30 March 2012

Re: Proposed Commercial Development, 84-86 Kiora Road, Miranda – Part 3A Concept Application (MP11\_0009)

We refer to the issues raised by NSW Planning and Infrastructure in relation to the subject Major Project as outlined in the Department's letter dated 14 February 2012, with particular reference to Schedule 1 – Carparking and Traffic. In this regard, we note that the amended plans incorporate our requested changes and accordingly, we are now able to advise as follows in relation to these matters, based on these amended plans.

basement floor plan
scale: 1:100

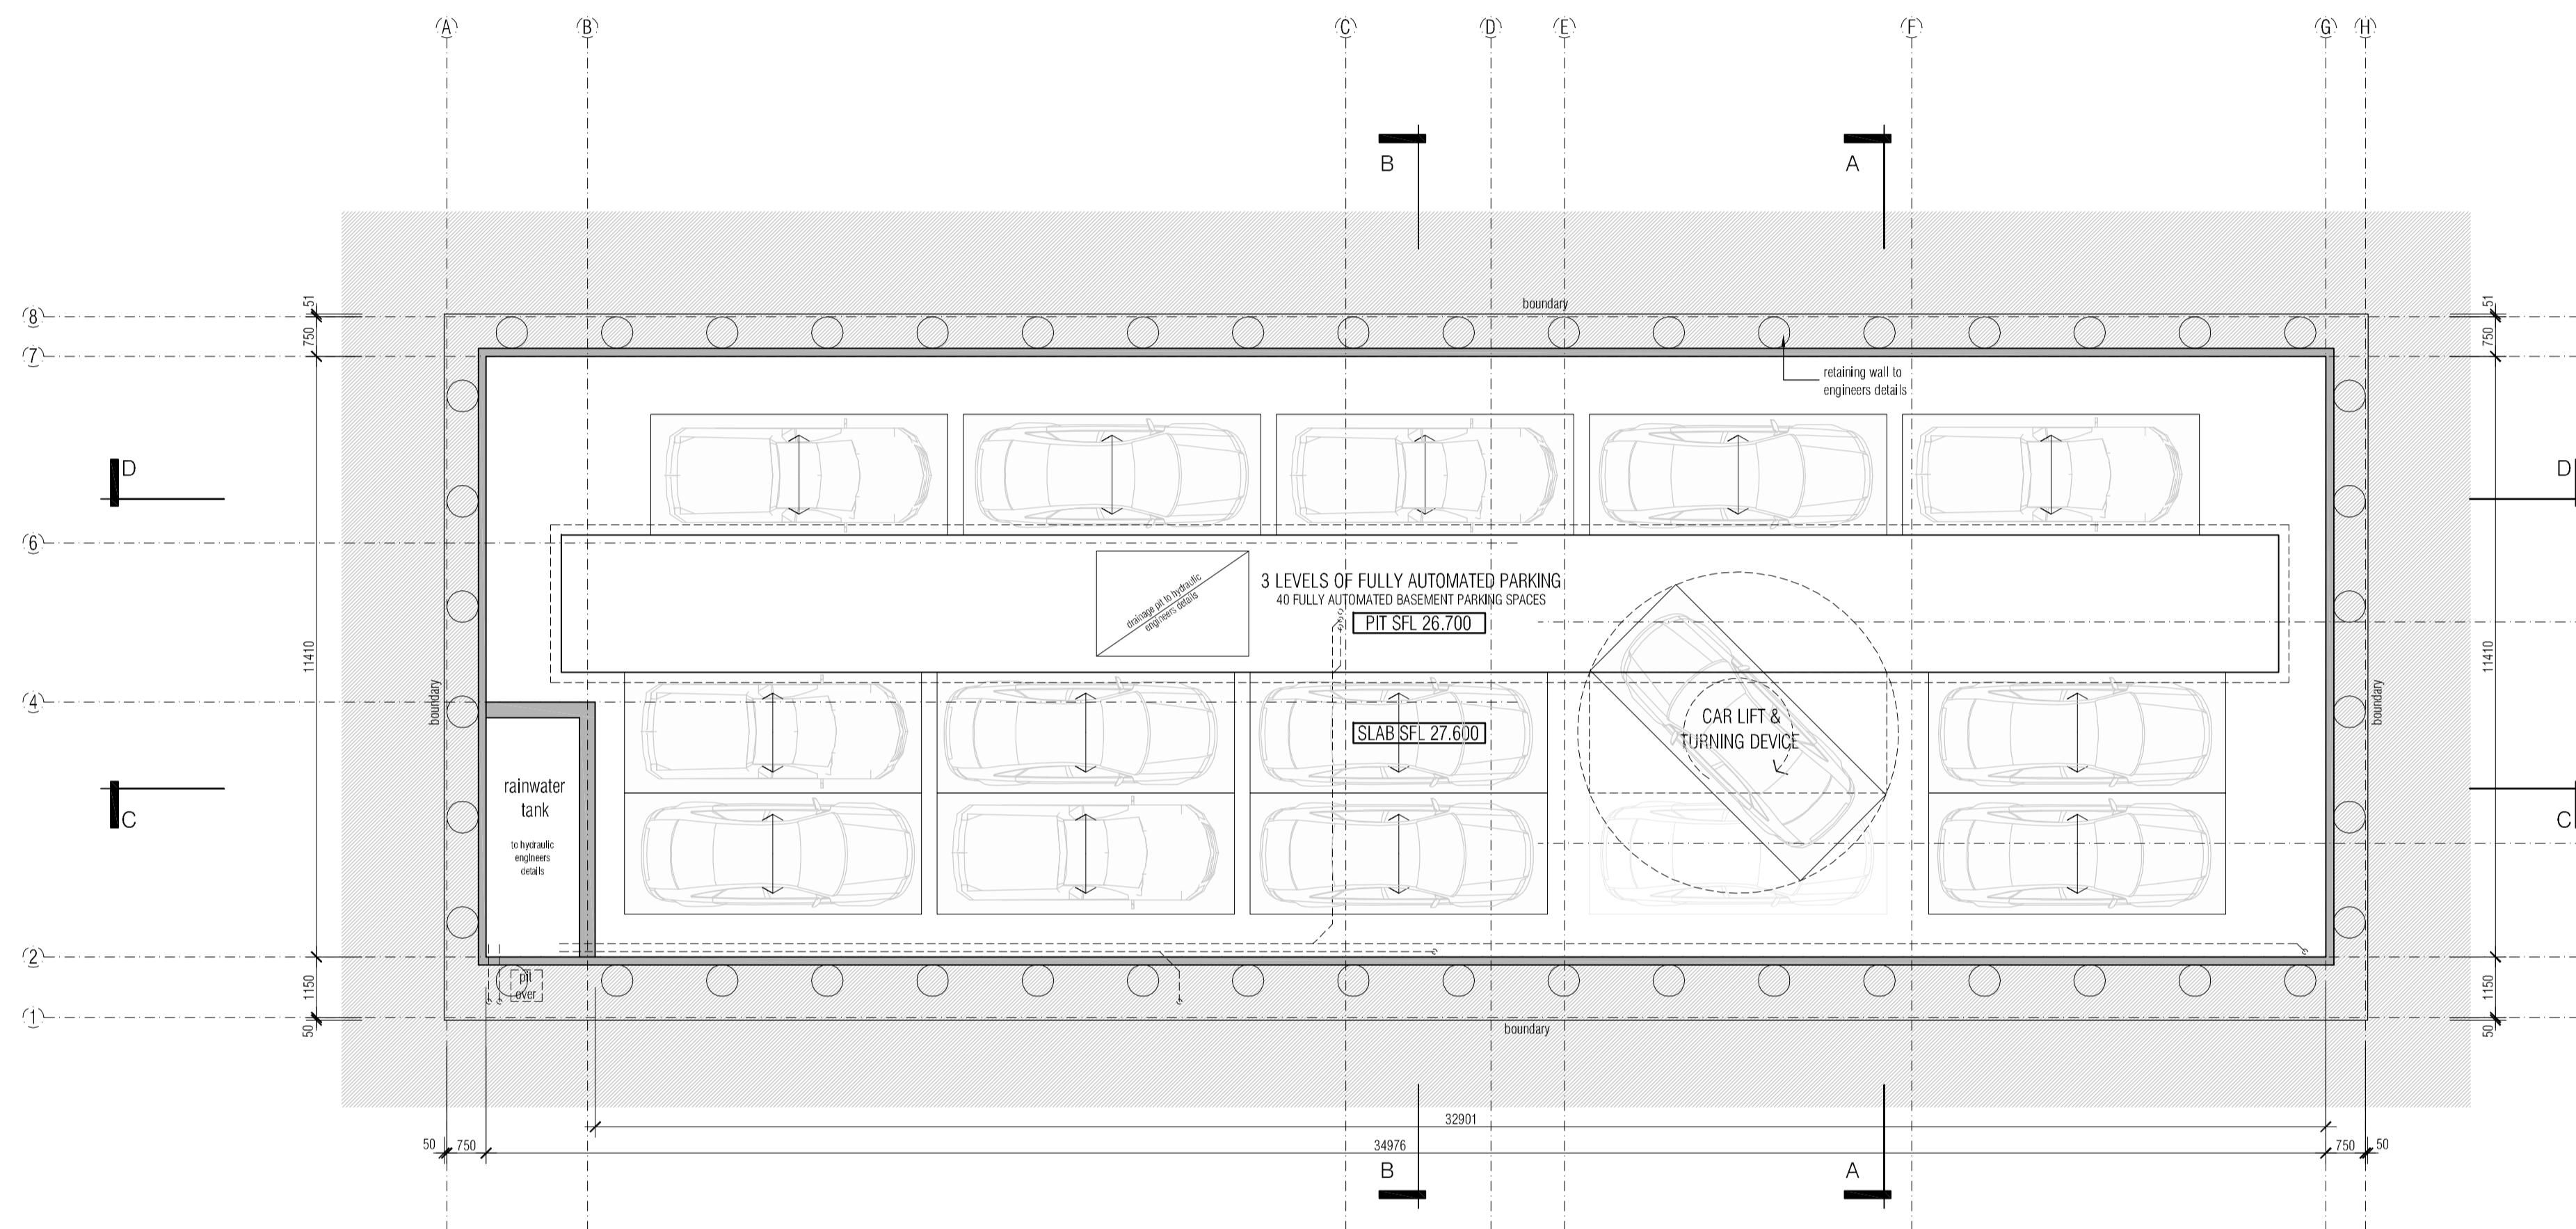
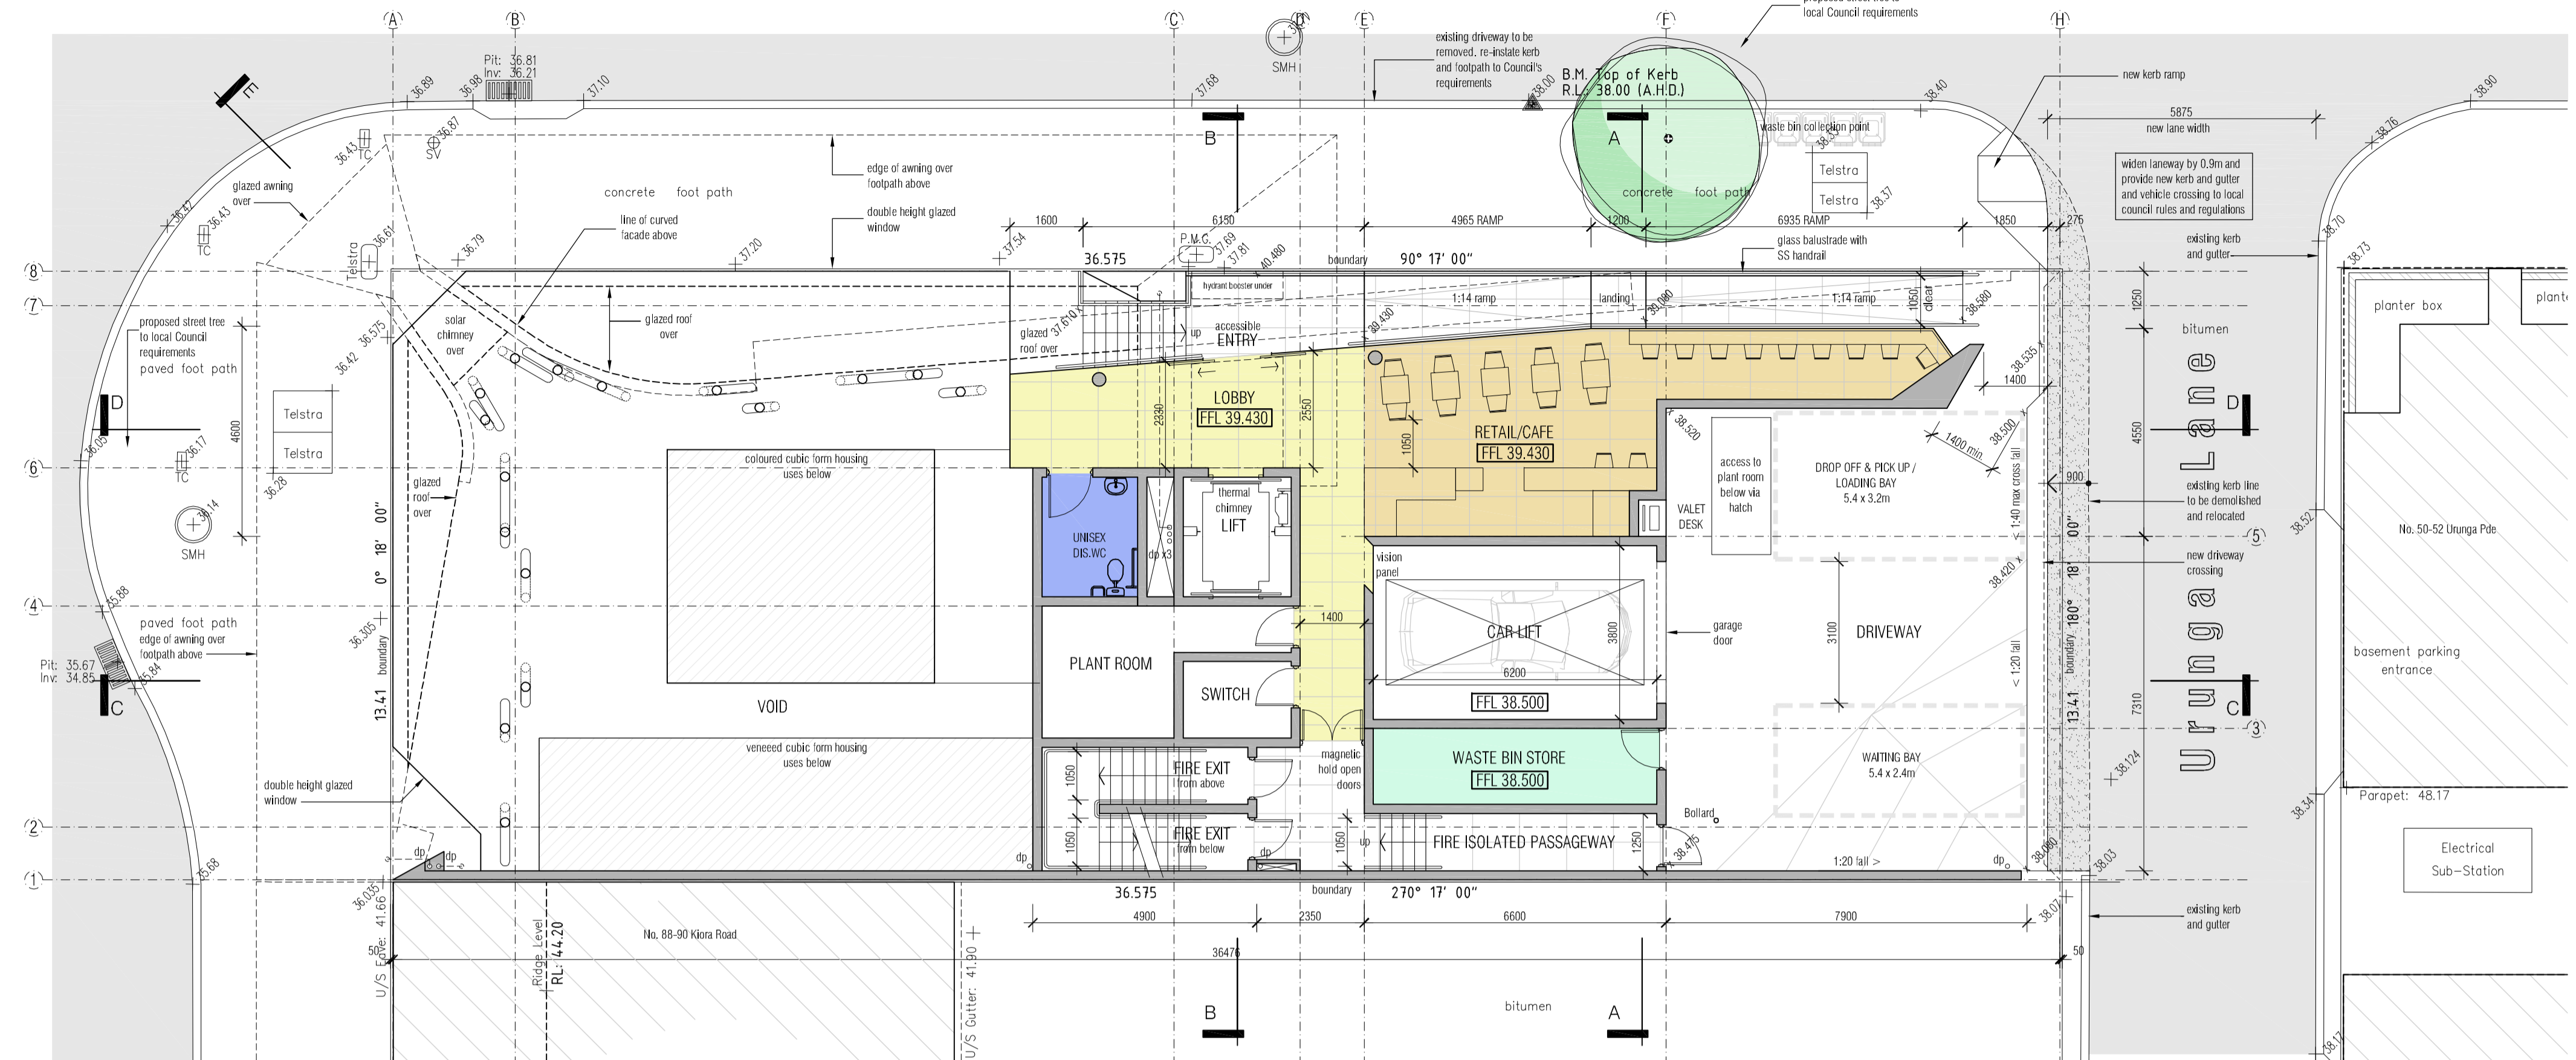
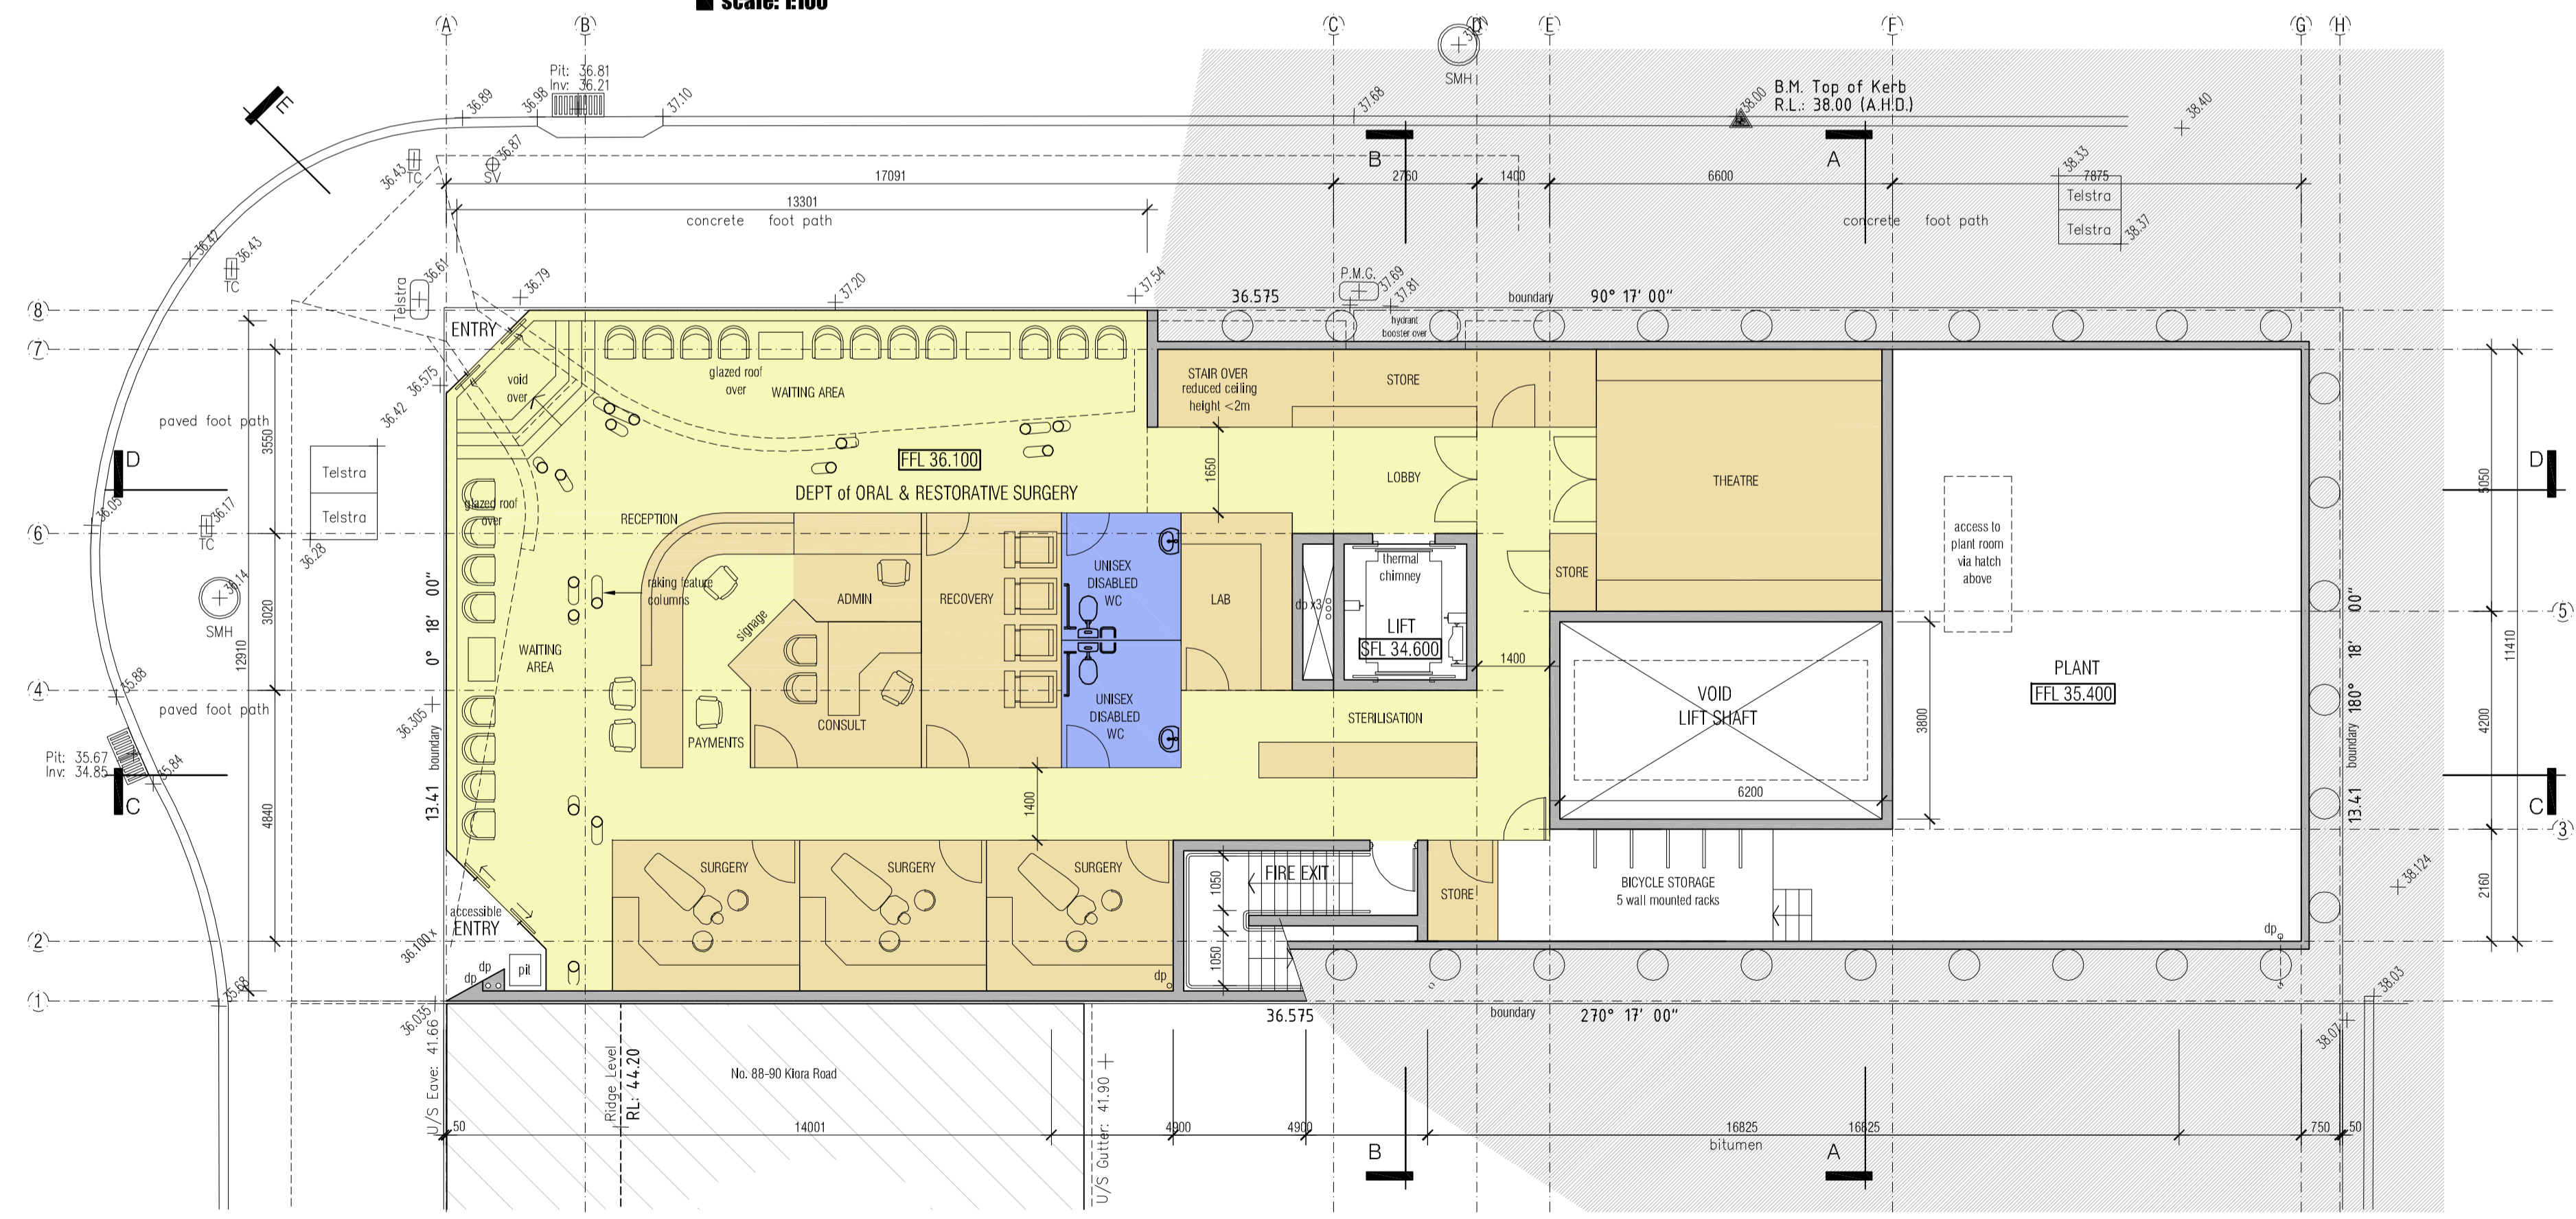
- ① No on-site patient car parking or pick-up/drop-off area.

- ① On street queuing associated with the use of the car stacker by 43 staff members

- ① Inadequate accessible and loading spaces.

The on-site parking (previously 43 spaces) has been reduced to 40 spaces. In addition, it is now proposed to allocate 30 of these spaces to staff and 10 to patients/visitors. As the access to spaces requires use of an automated stacking system, it is proposed that all visitors will leave their car on the main apron area, with the car placed into the stacker by a valet who will be on-site after 8am. Set-down and pick-up activity can occur within the large apron adjacent to Urunga Lane. In addition, there is extensive on-street parking in the immediate locality, including adjacent to the site in Kiora Road. The existing 15 minute parking adjacent to the site in Kiora Road is specifically intended for pick-up and set-down activity. It has a length of 26 metres and can accommodate four cars.

The previous plans proposed a shared loading bay/disabled parking space. The current proposal is to allow a disabled driver to park within the apron adjacent to Urunga Lane, for the valet service attendant to then park their car on the 'pallet' which is part of the automated car stacking (Klauss) stacking system. Disabled drivers are provided with an accessible ramp to gain entry to the main lobby from the lift apron area.

Loading will occur only very occasionally throughout the day using the apron area, generally outside peak arrival times. This area is very wide (over 10 metres) and access has been improved by the widening of the lane and the setback of the apron by 7475mm from the property boundary, so that a 6.4m SRV can stand wholly within the site.

The road reserve of Urunga Lane has been widened by 900mm to provide sufficient width for two vehicles to pass within the lane, which is a significant public benefit. Although the provision for allowing a vehicle to pass a waiting car is not a design requirement (as discussed above) and the new road widening does not present any substantive benefit to the subject site, the proponent has agreed to accommodate this improvement in the public interest and to overcome any potential for queuing or delays within Urunga Lane. In addition, we note that the apron area in front of the lift is 7475mm wide, so that no queued vehicle will extend beyond the site boundary.
